Charlotte Department of Transportation

Memorandum

Subject: Rezoning Petition 08-057: Located on the south side of East 36th Street between North Davidson Street and the Norfolk Southern Railroad (revised 2/16/08)

FOR PUBLIC HEARING PETITION #: 2008-057
 REZONING SURVEY OF:
DEBORAH MICHELLE NORKETT
 LOTS 3 & 4, BLOCK 1,
 MAP BOOK 230, PAGE 14
 446 EAST 36TH STREET
 CITY OF CHARLOTTE, MECKLENBURG COUNTY, N.C.
 DEED REFERENCE: 8460-388
 TAX PARCEL: 083-084-19

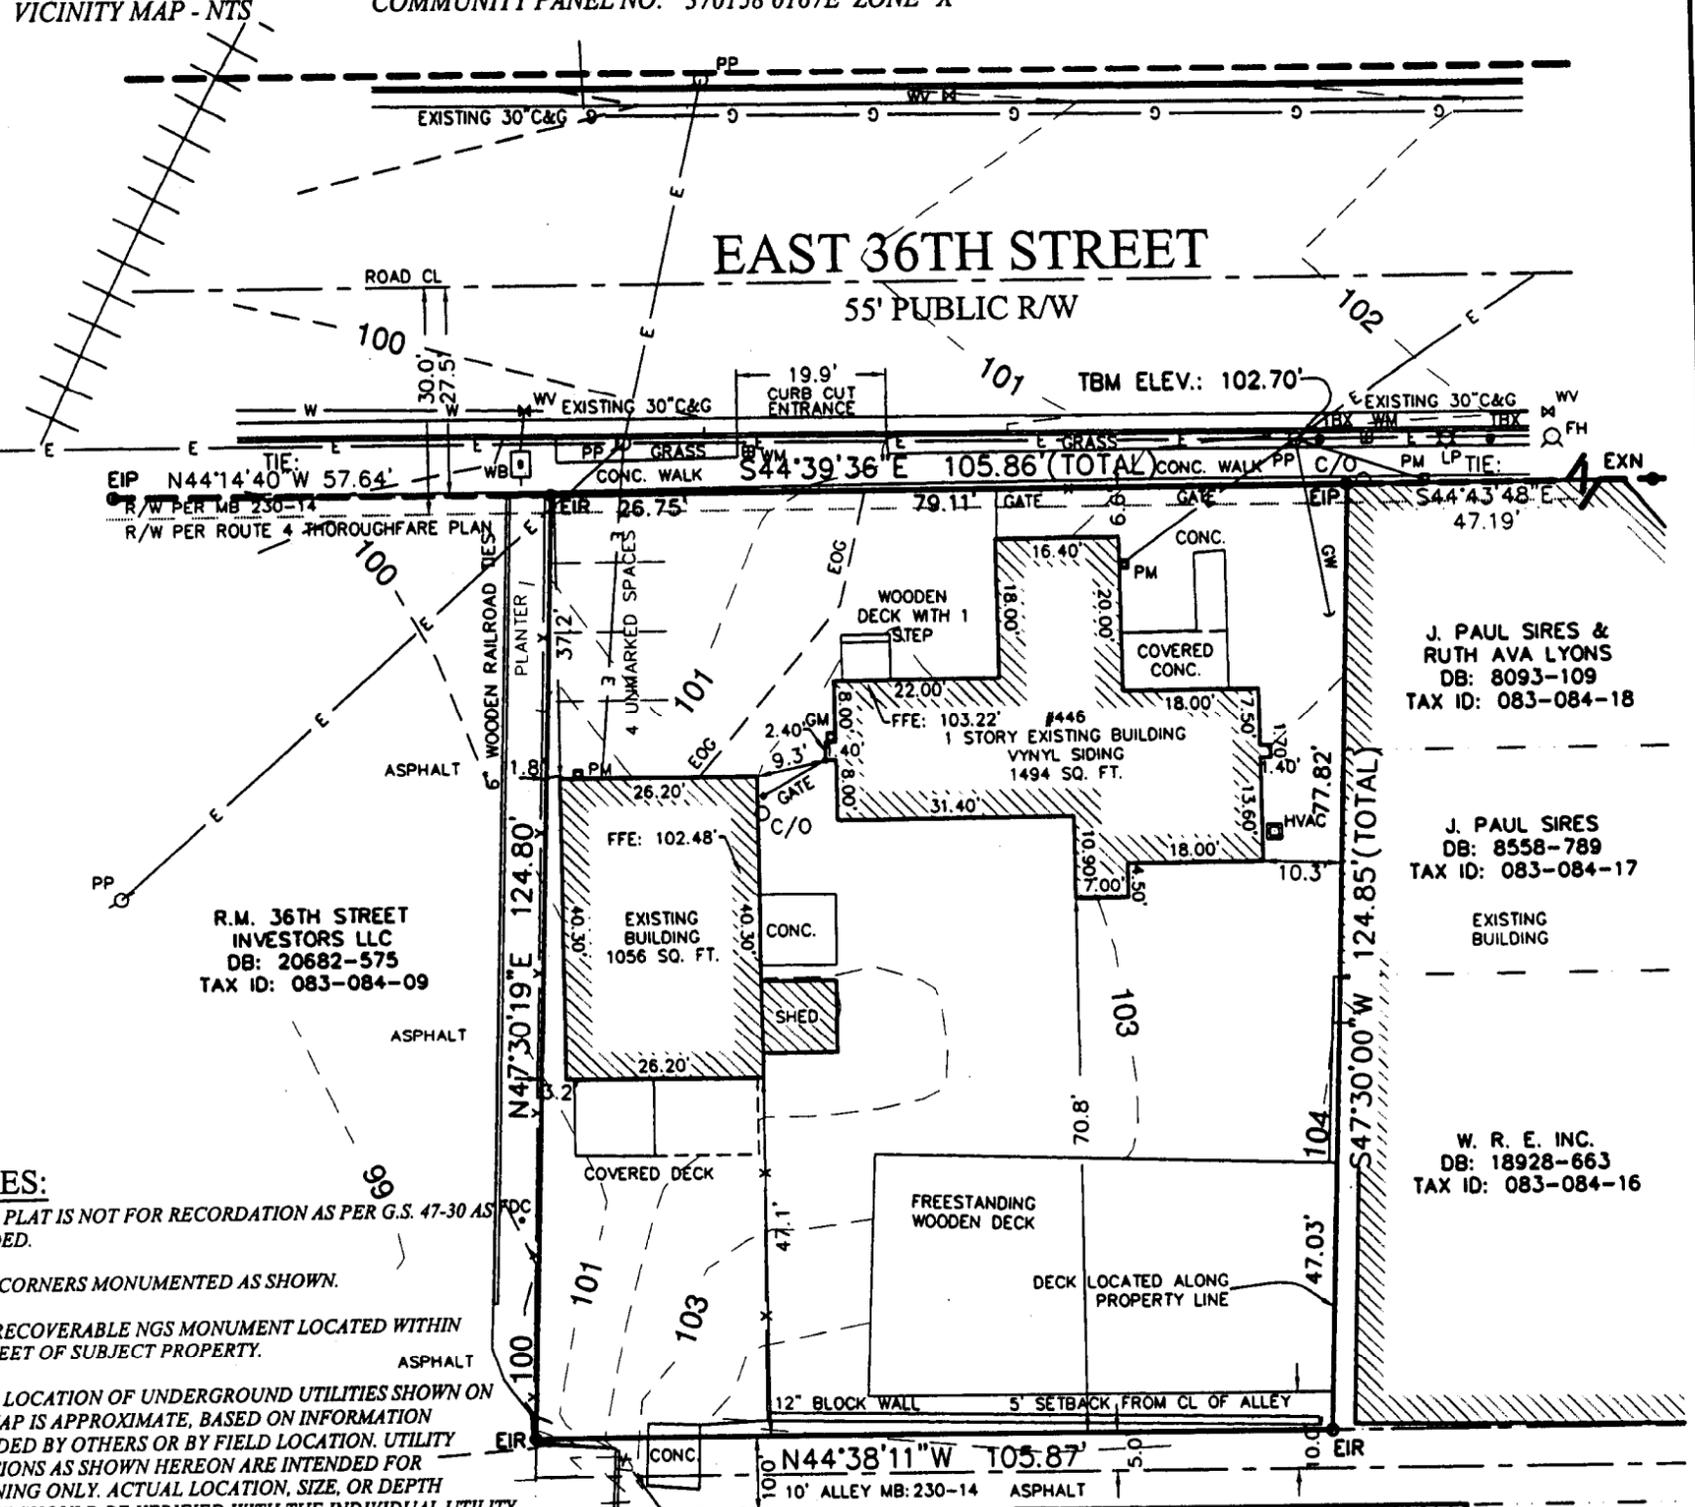
1. A proposed development site plan is needed (survey provided) showing any driveways, off-street parking and sidewalks in order to fully-evaluate the petition. (*Previous review comment*)

1. East 36th Street is classified as a Main Street using the street typology in the Urban Street Design Guidelines (USDG). As such, driveways are strongly discouraged, while wider sidewalks are strongly encouraged. (*Previous review comment*)
2. The NS zoning district requires 8' (minimum) planting strips and 6' (minimum) sidewalks. Main Streets need a minimum of 10-foot sidewalks, unless there are constrained conditions. Until a site plan is submitted that identifies any constrained conditions, we cannot support a sidewalk width less than 10 feet. (*Previous review comment*)
